Appeal Decision

Appeal Ref: 6003796

19 Pendle Street East, Sabden, Lancashire BB7 9EQ

- The appeal is made under section 78 of the Town and Country Planning Act 1990 (as amended) against a refusal to grant planning permission.
 - The appeal is made by Mr and Mrs Whitehurst against the decision of Ribble Valley Borough Council.
 - The application Ref is 3/2025/0531.
 - The development proposed is new build single storey dwelling house within existing garden curtilage.
-

PROPOSED SITE BLOCK PLAN 1:250

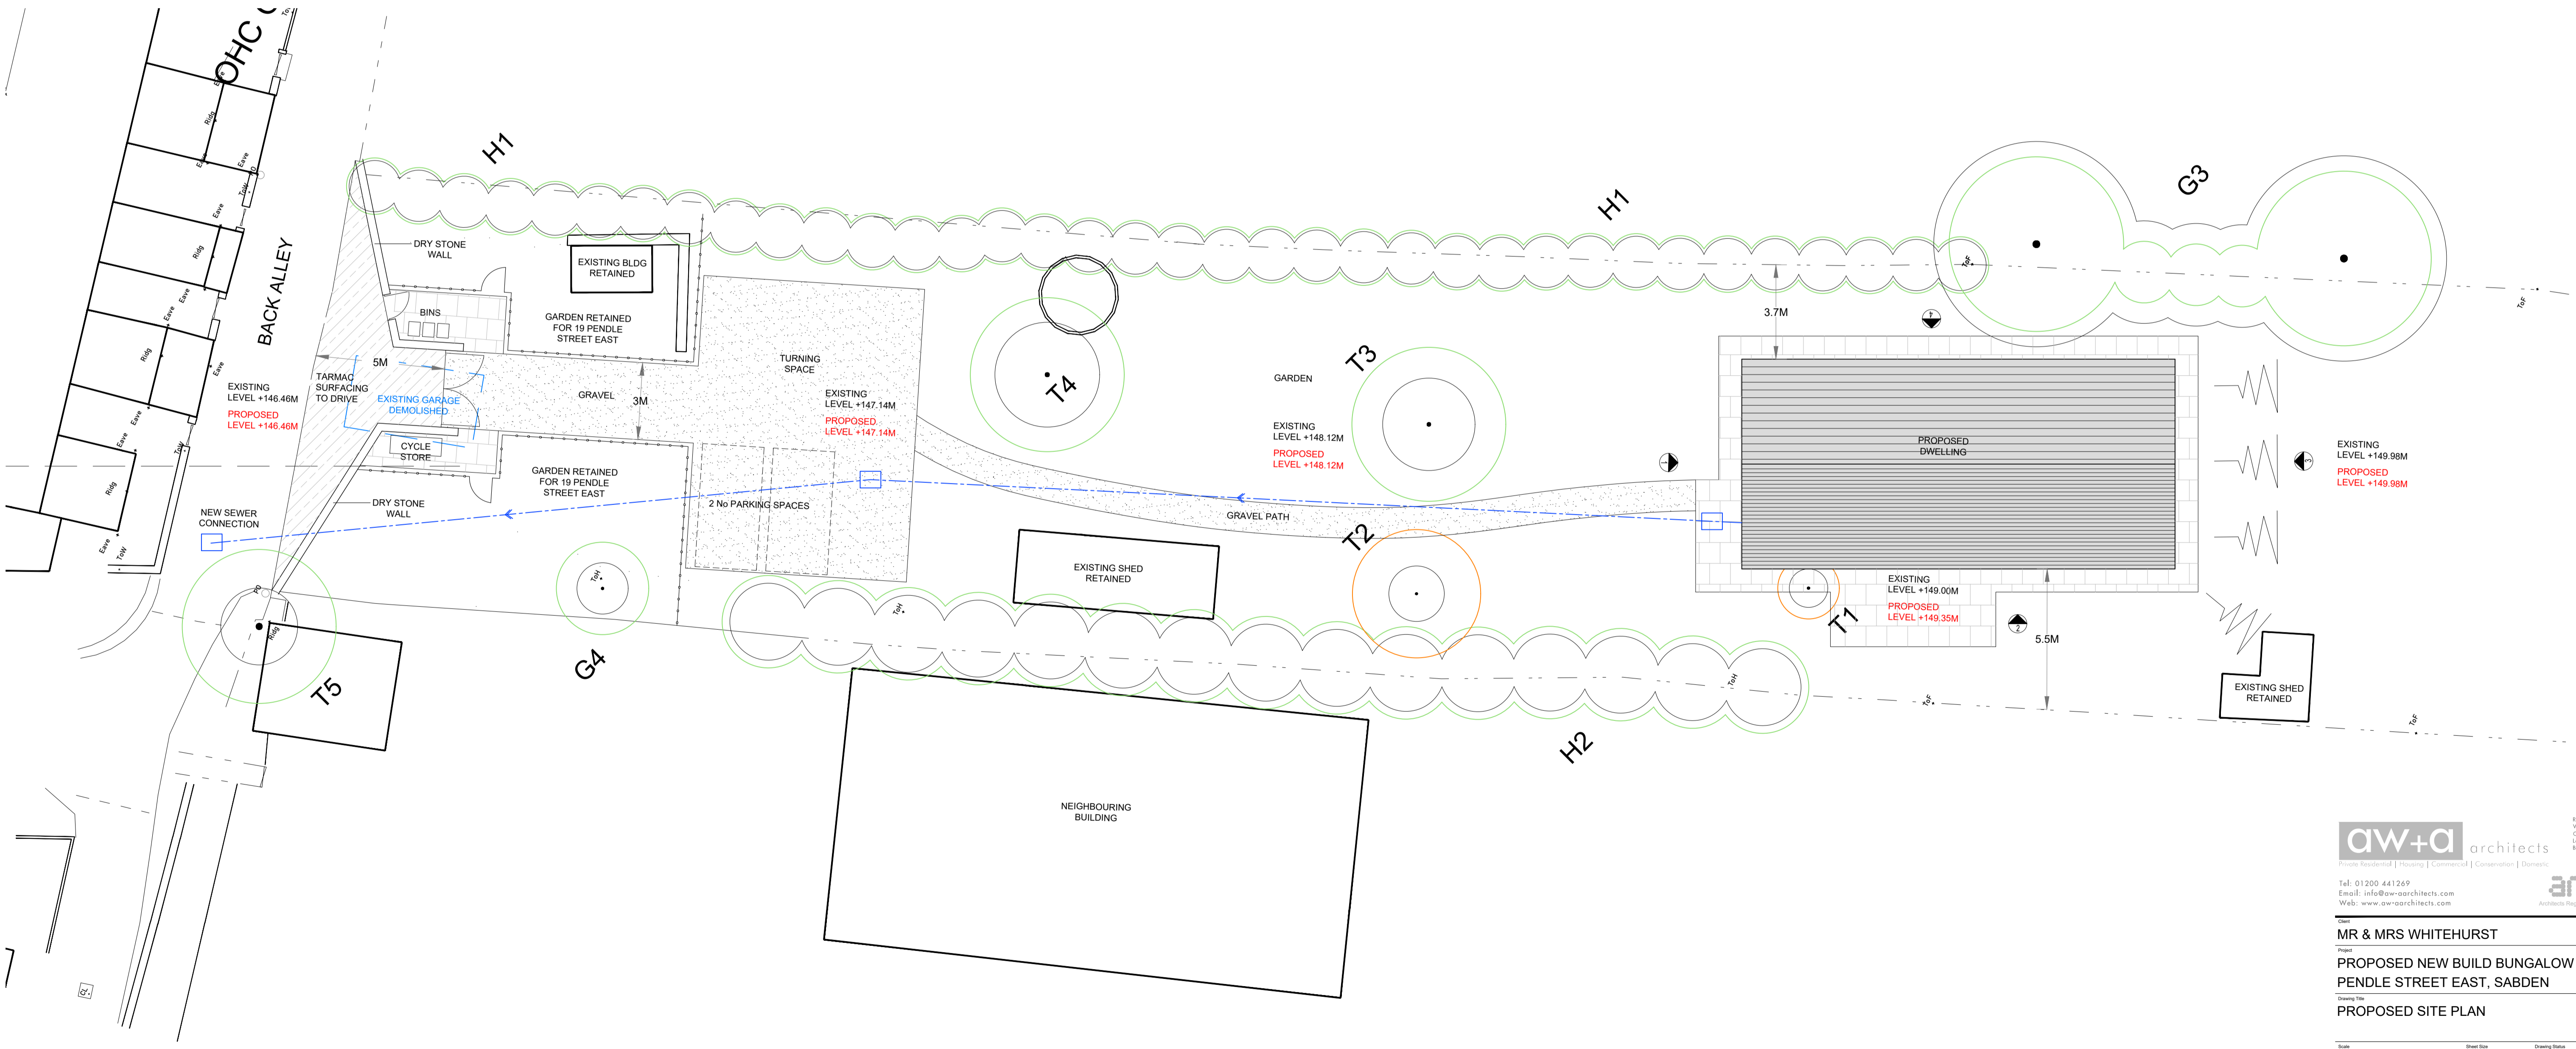
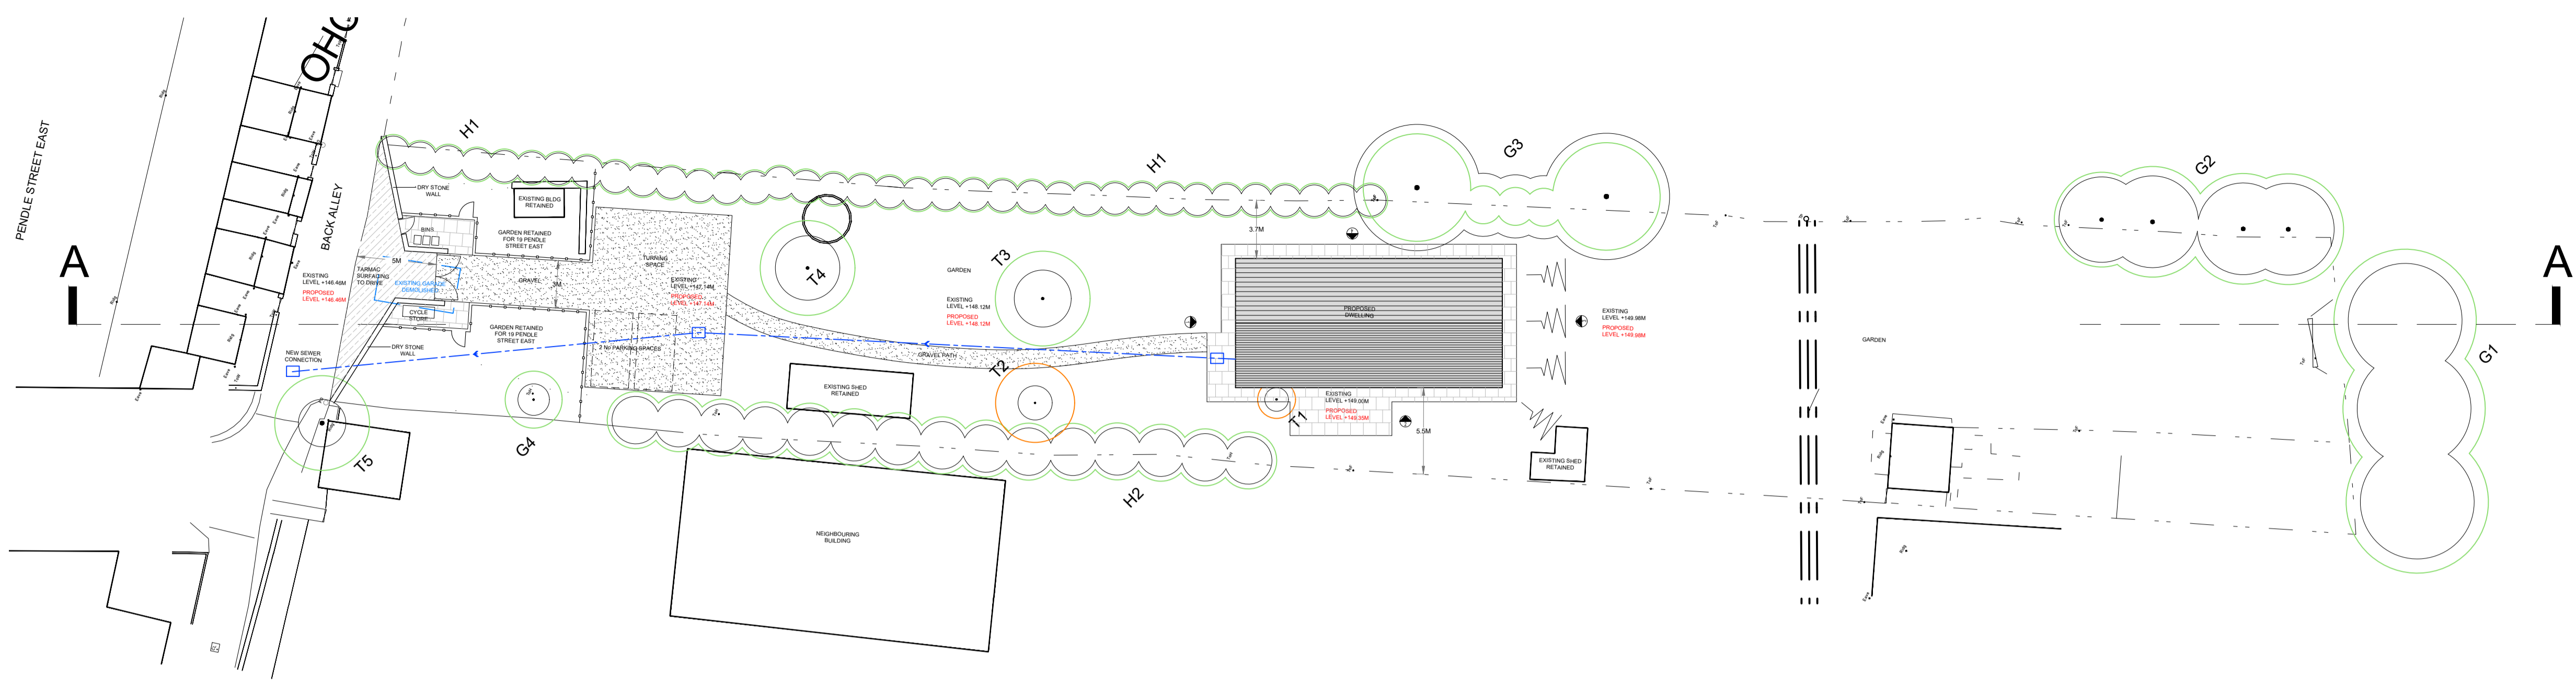
23. The site is generally well contained by existing boundary treatments, although a section of the eastern boundary is more open and allows some views into the site. The lower part of this boundary is formed by a hedgerow, which provides a soft transition to the adjoining field. A similar hedgerow treatment could be extended along the remainder of the boundary and secured by condition, helping to screen the dwelling and associated domestic activity.

1. NATURAL SLATE
2. CHARRED VERTICAL TIMBER CLADDING
3. ALUMINIUM OR UPVC WINDOWS
4. PV PANELS

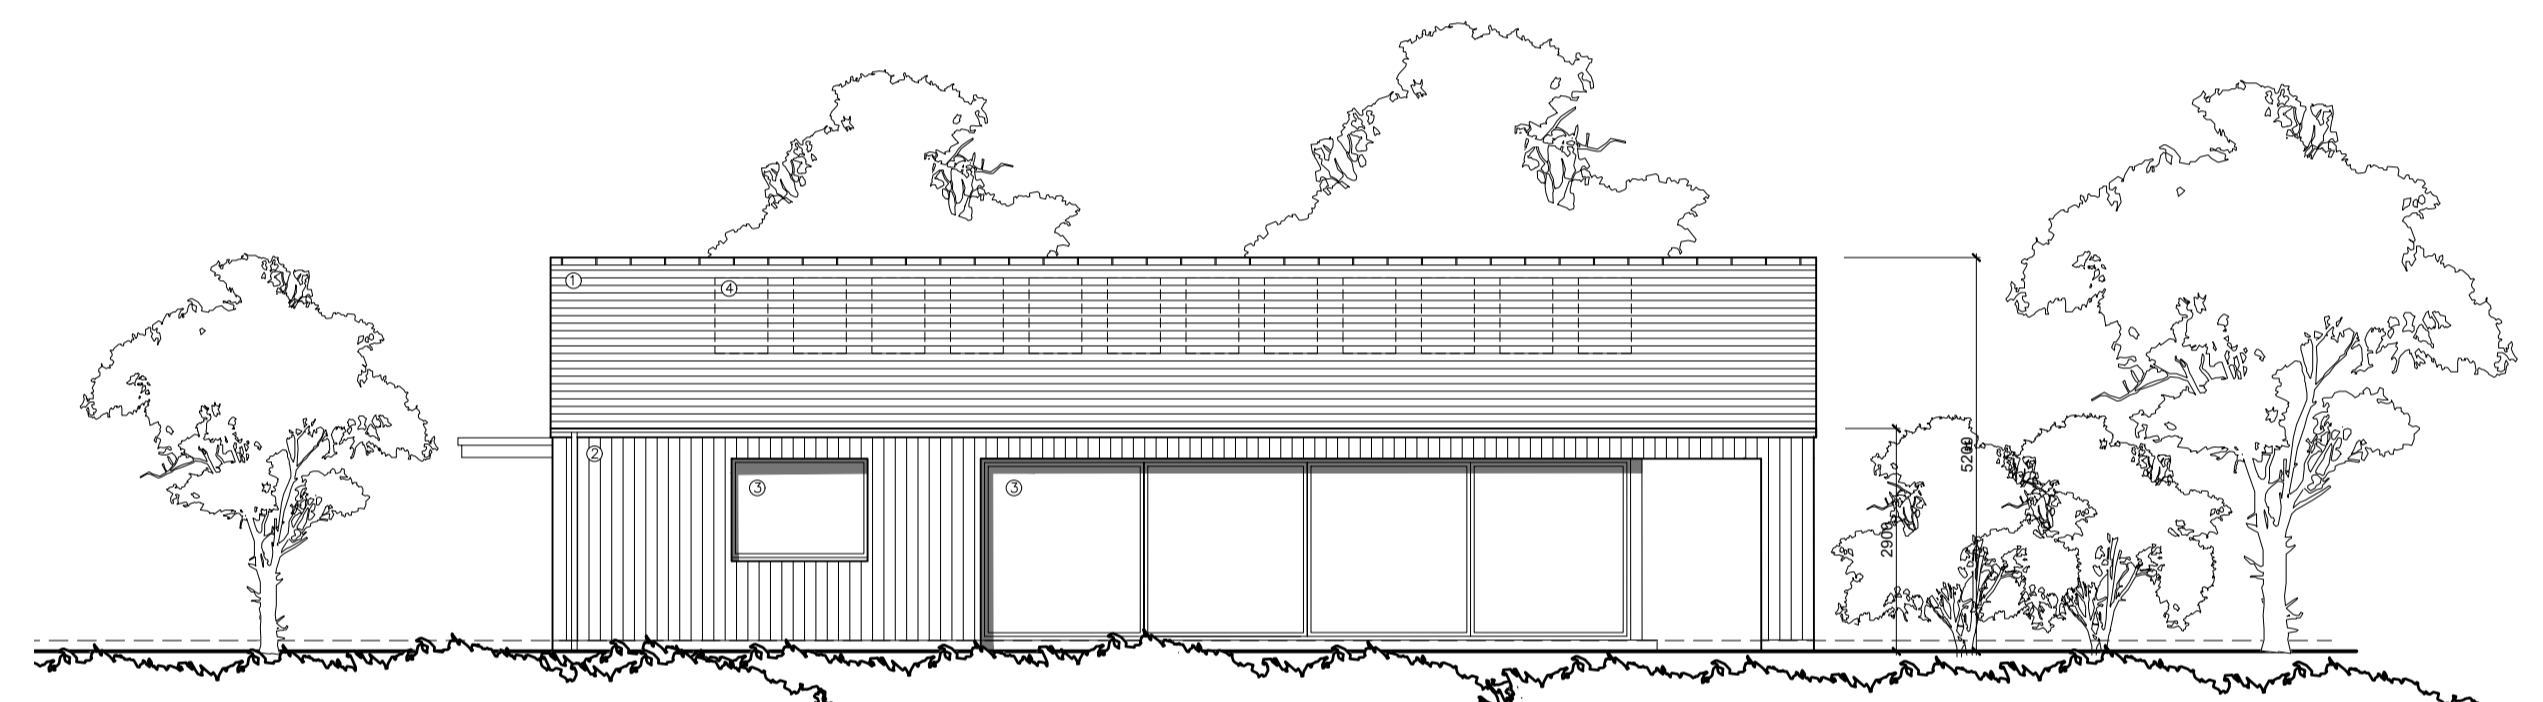
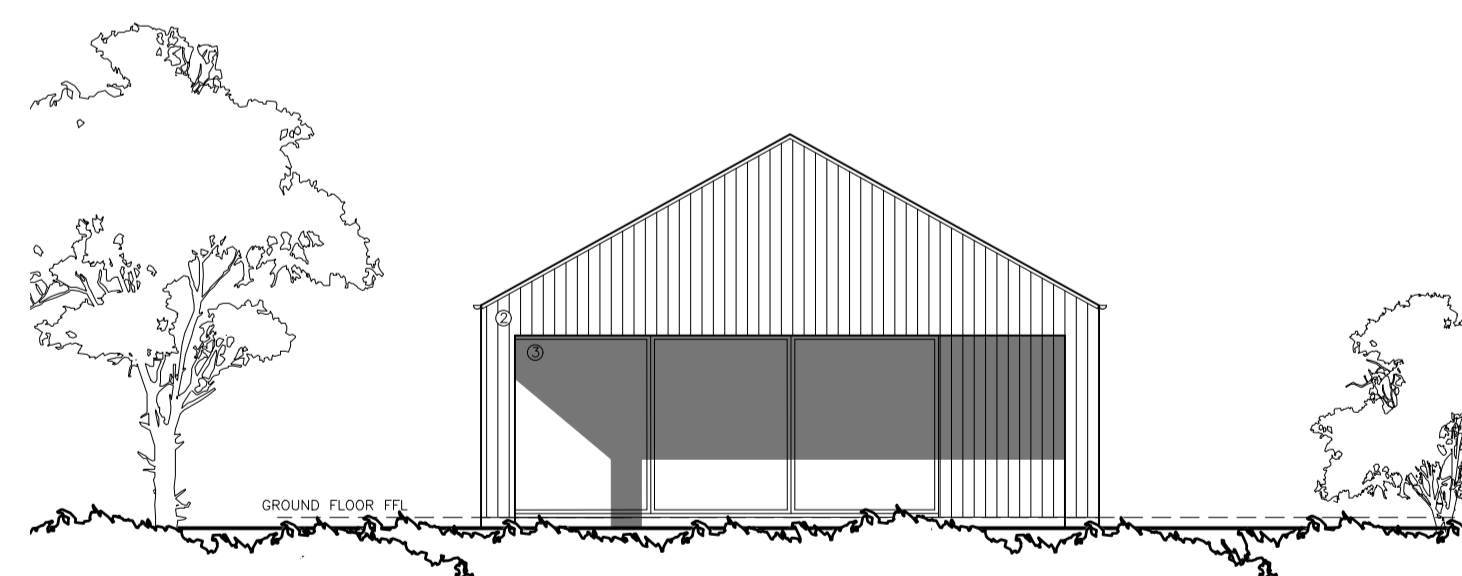
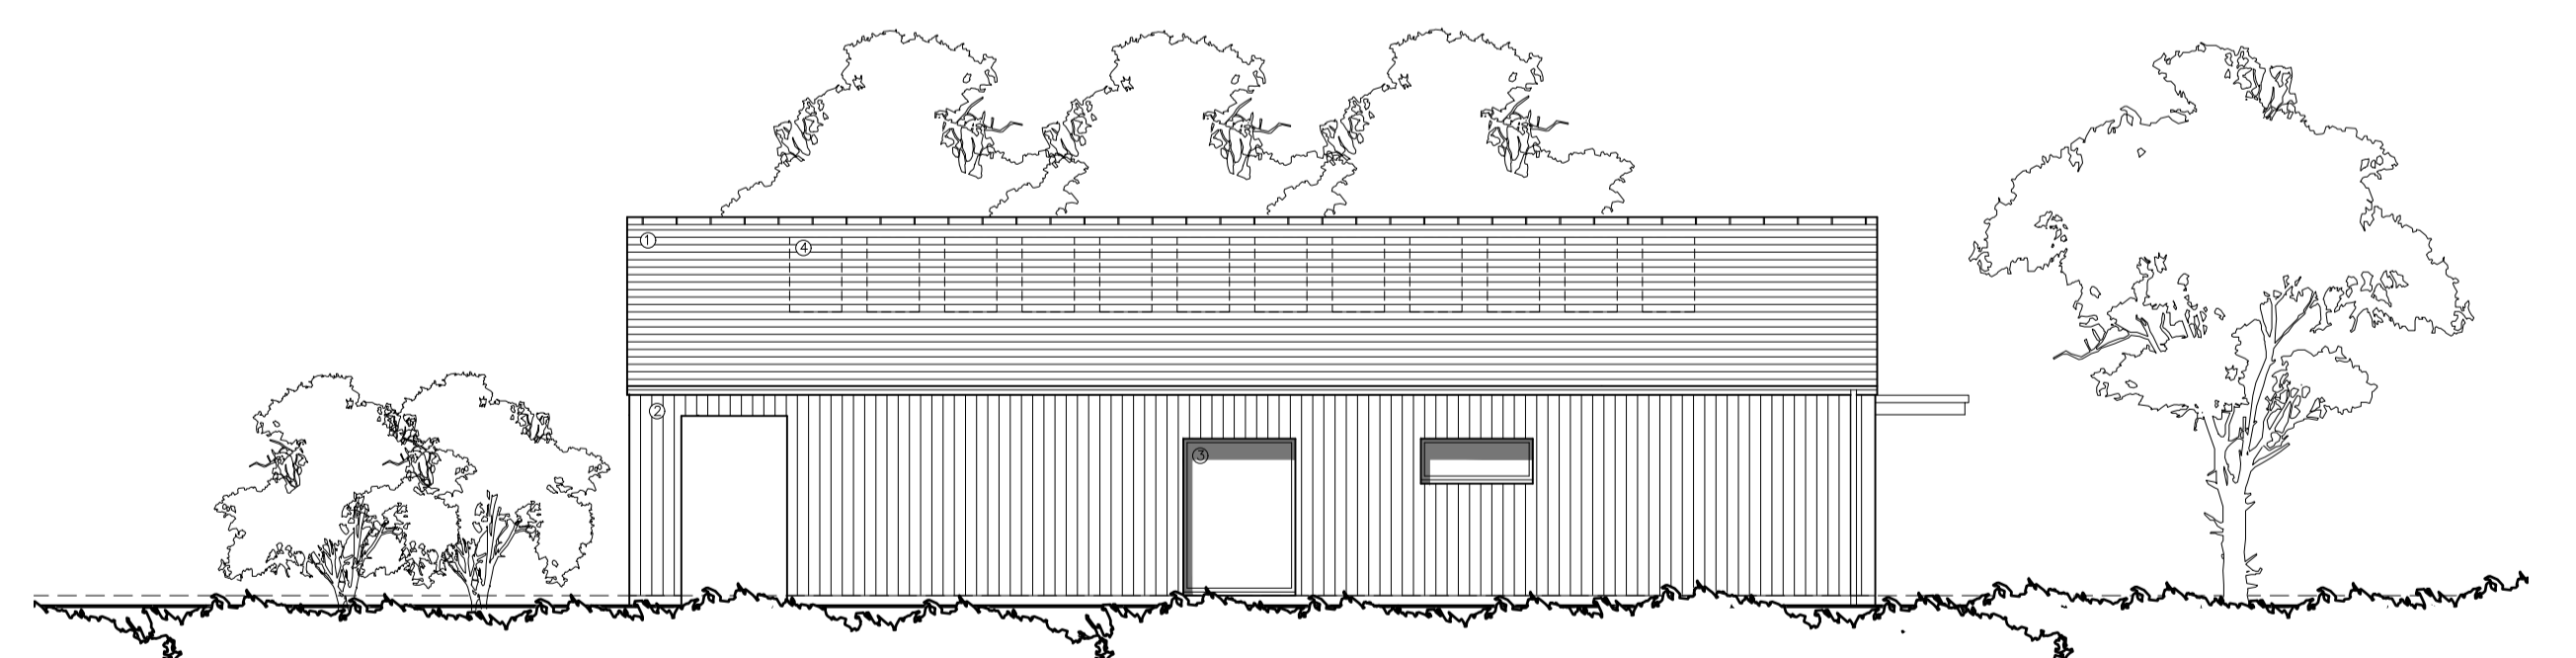
2. As part of their submission, the appellant has provided an amended scheme which would replace the timber cladding on 2 elevations of the dwelling with render. It is not the purpose of the appeal process to evolve a scheme, and it is therefore important that what is considered by the Inspector is essentially the same scheme before the Council and interested parties at the application stage. I have nevertheless considered whether to accept the amended plans.

3. Having regard to case law, I conclude that, whilst the amendments do not constitute a substantial change to the scheme determined by the Council, I am mindful that those who should have been consulted on the changed development have not had the opportunity to make representations. I therefore cannot be certain that accepting the alternative proposal would not be prejudicial to interested parties. Furthermore, the appellant has made it clear that the original proposal remains the preferred option. I have therefore determined the appeal against the plans considered by the Council when it made its decision.

24. Although the proposal would not follow the design of the terraced dwellings to the north, its separation from them means that combined views would be limited. The use of timber cladding would therefore not appear discordant with the traditional stone buildings and the finish would not be dissimilar to domestic outbuildings in the vicinity or the appearance of buildings often seen in the rural landscape. The well contained nature of the site would limit views of the timber cladding with the slate roof likely being the most visible part of the building from the east. This is reflective of local building materials, so would be in keeping with nearby development in this regard and the dark colour would help it assimilate within the landscape.
